OA2026/0013

Subject: State Significant Development.
Application No: OA2026/0013.
Property: 120-130 McCredie Road Guildford.
Proposal: Other Authority Consent - Request for advice for Guildford West Battery Energy Storage System (SSD-83916959).

Appendix A - Comments

Figure 2-1: Proposed Guildford West BESS project layout

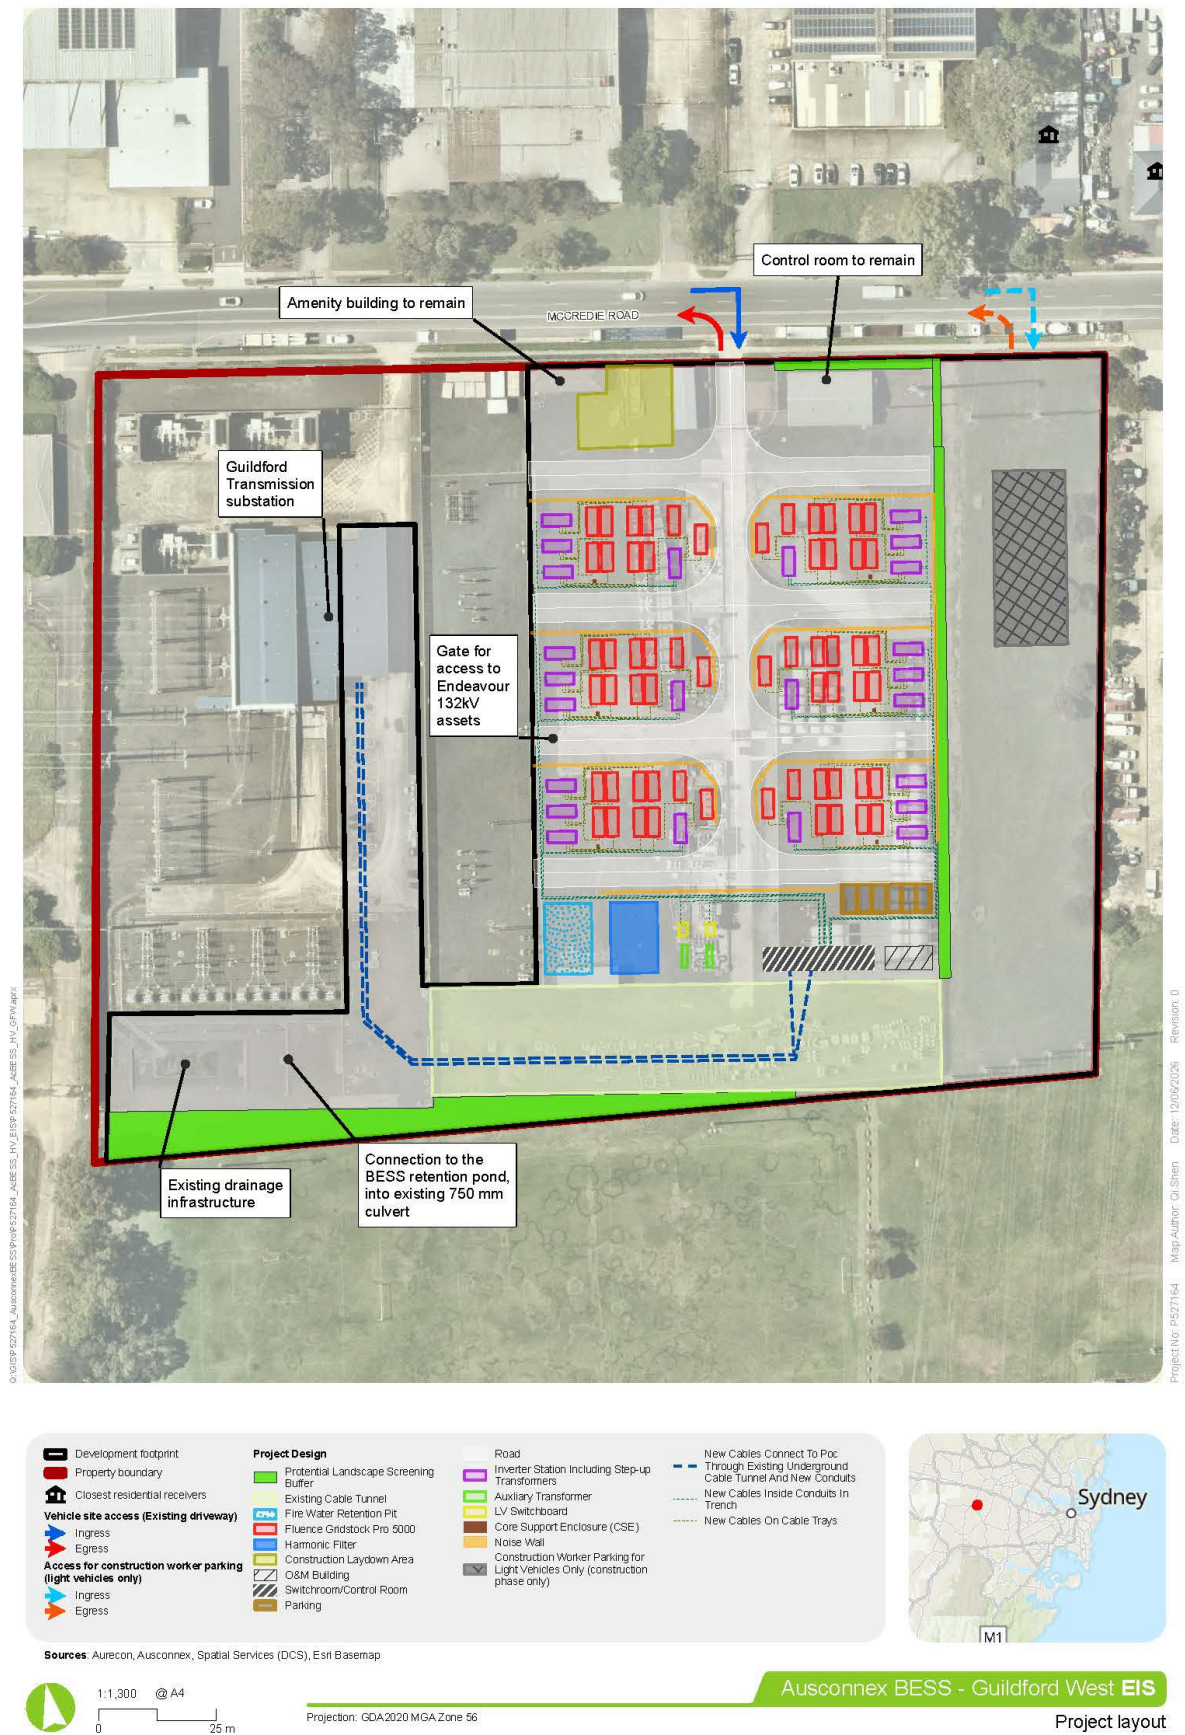
Additional Landscaping to reduce Heat Island Effect

Large-format industrial buildings and extensive hardstand areas can significantly contribute to urban heat island effects especially when located near open space and residential areas. Council recommends increasing landscaping across the site including:

- Deep-soil planting zones along the southern interface with Tarrawarra Reserve.
- Perimeter planting along the boundary using native species.
- Vegetation buffers.

Whilst no protected trees or vegetation are proposed to be removed as part of the development, the proposal highlights that a Light vehicle parking area for construction workers during the construction phase of the development will be required. Council recommends that tree protection fencing be erected to protect existing site vegetation and provide an exclusionary zone for the trees to ensure that their health and vitality are not impacted by the works.

It is recommended that new plantings be implemented along the McCredie Road frontage to soften the visual impact the development from the adjoining industrial and residents lots.
